Consultation Response from: KC Environmental Health (Pollution & Noise Control)
2026/90425 - Land at Shop Lane, Kirkheaton, Huddersfield, HD5 0DB
Discharge of details reserved by condition 15 (noise) on previous permission 2014/92535 for outline application for erection of 48 dwellings, formation of access and associated infrastructure
**Responding Date:
02 March 2026**
**Responding Officer:
Mohammed Nasim**
**Responding Ref:
WK202605109**
Comments

The applicant has submitted a Noise Assessment authored by Hepworth Acoustics dated March 2021 Ref P21-061-R01v1.

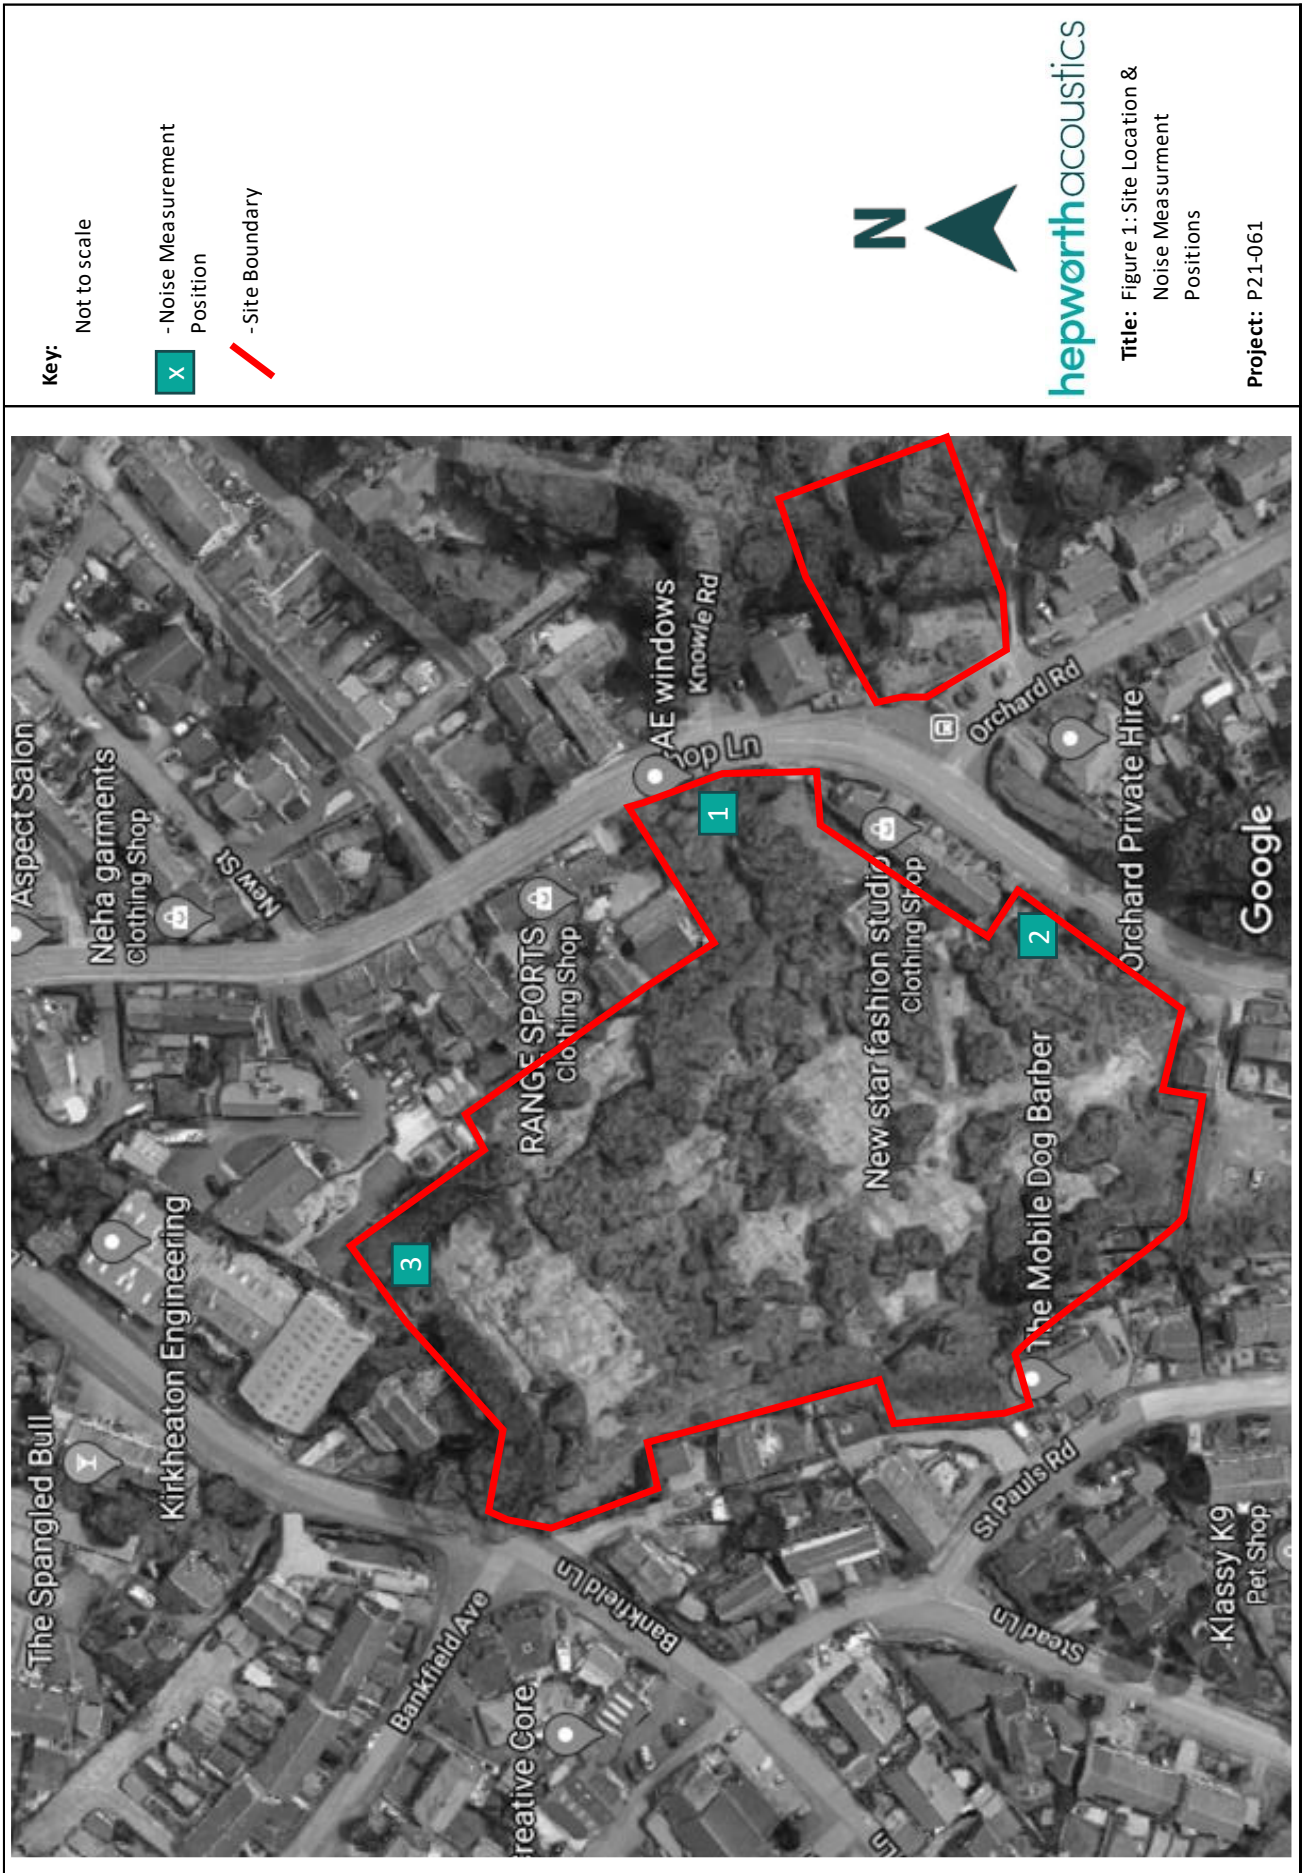
A noise survey was conducted between 1440hrs on Monday the 8th of March and 1440hrs on Tuesday the 9th of March 2021 from three monitoring positions as shown on figure 1 on page 9 and a summary of the findings is given in table 2. Comment is made that Kirkheaton Engineering Co Ltd did not appear to be open or operating during either of their visits to the site and therefore it was not possible to determine the likely noise impact from their operations. Of note is that this assessment was conducted during the COVID pandemic with the author stating the results are similar to the findings undertaken for the outline planning permission.

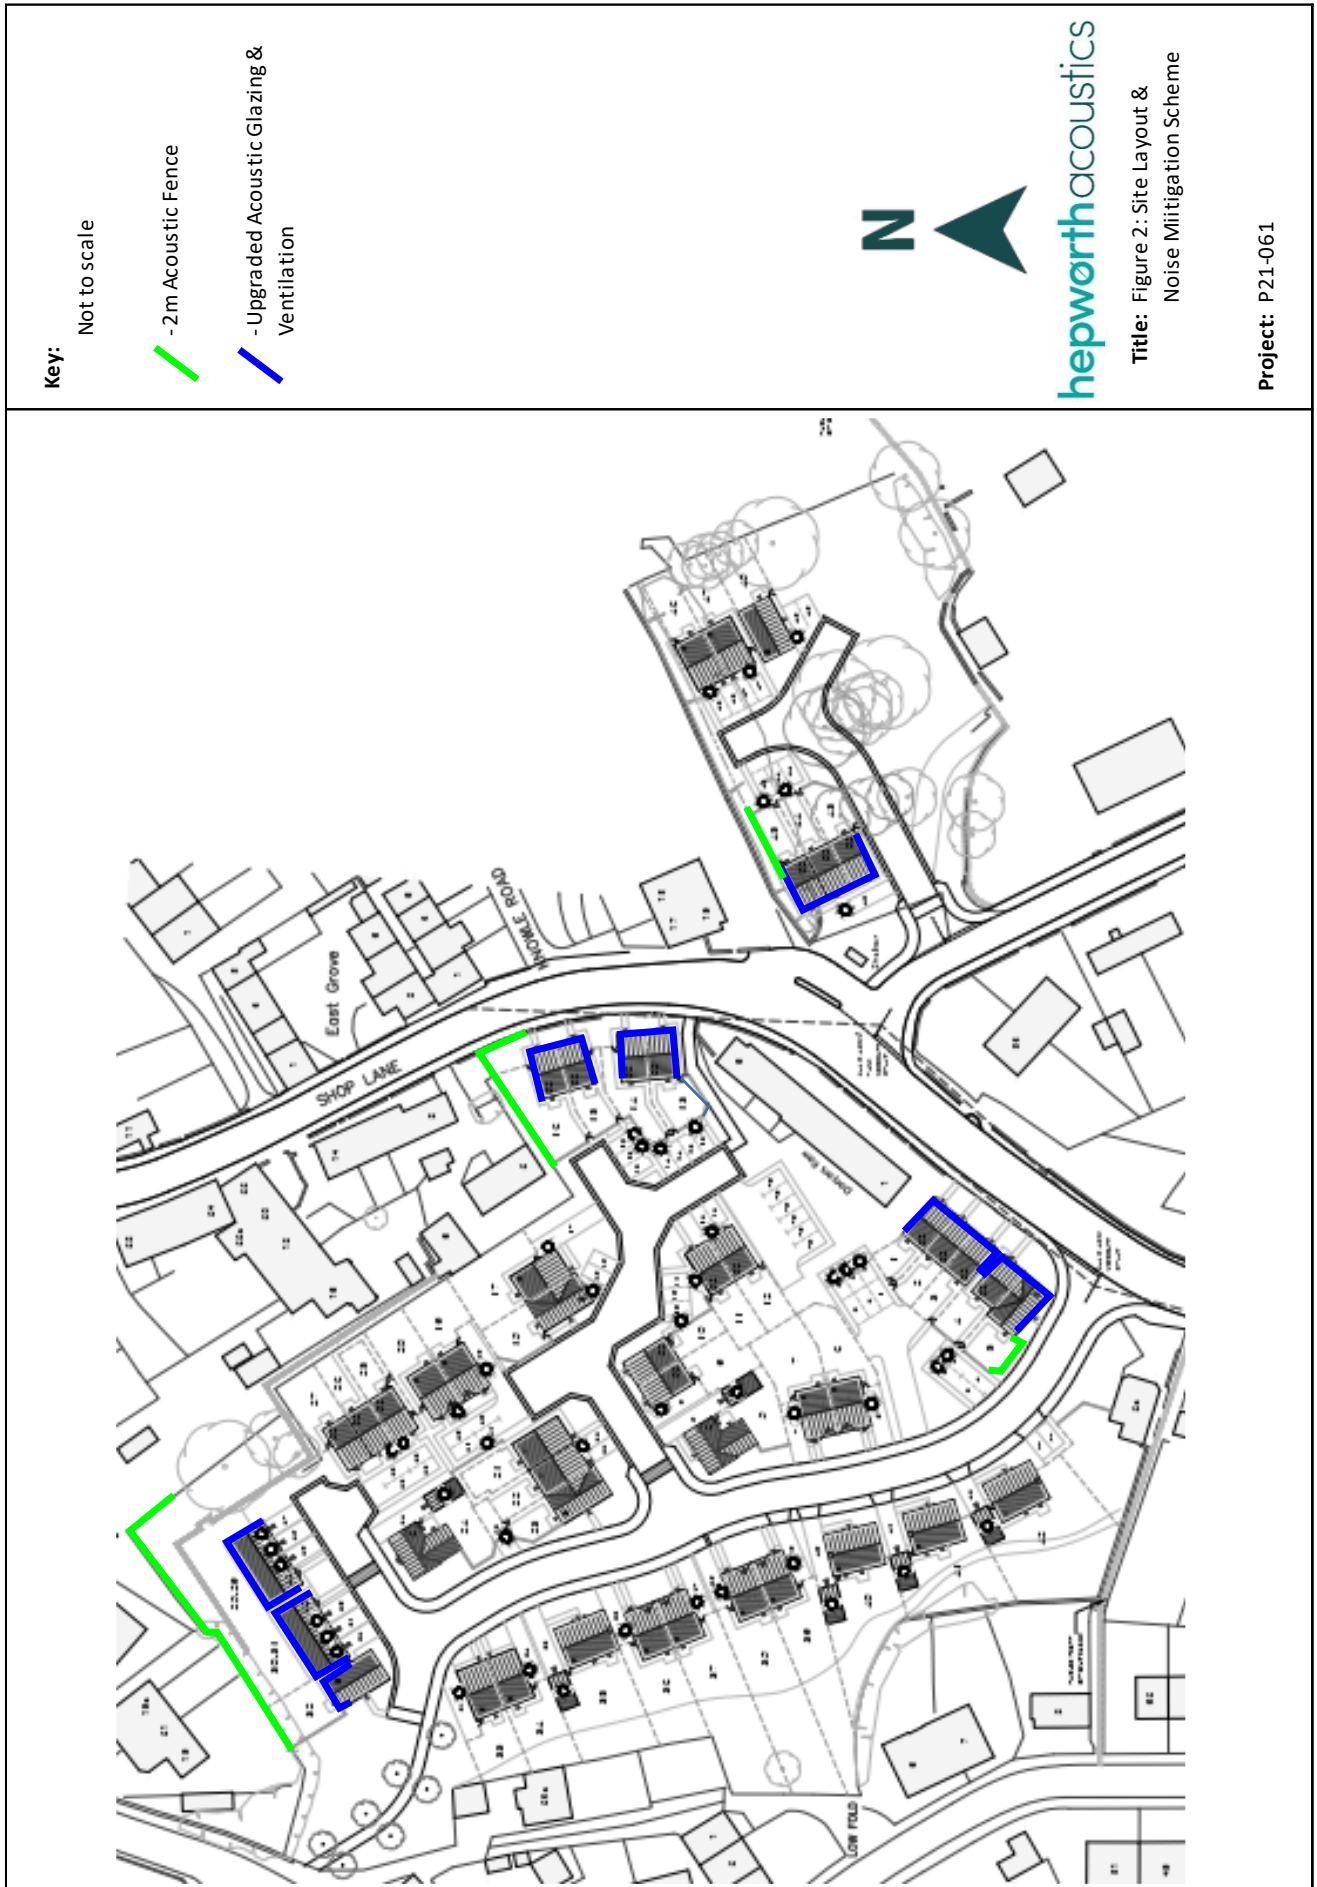
In order to meet with the internal requirements of BS8233, glazing and acoustic ventilation is specified to those plots as shown on figure 2. Standard double glazing is recommended for the remainder of the site. Para 4.14 recommends minimum construction mitigation in any bedrooms in roof spaces on outward facing elevations closest to the Shop Lane.

In order to meet with the external requirements of BS8233, a minimum 2m high acoustic fence is recommended to the plots as shown on figure 2. A minimum specification is given in para 4.6.
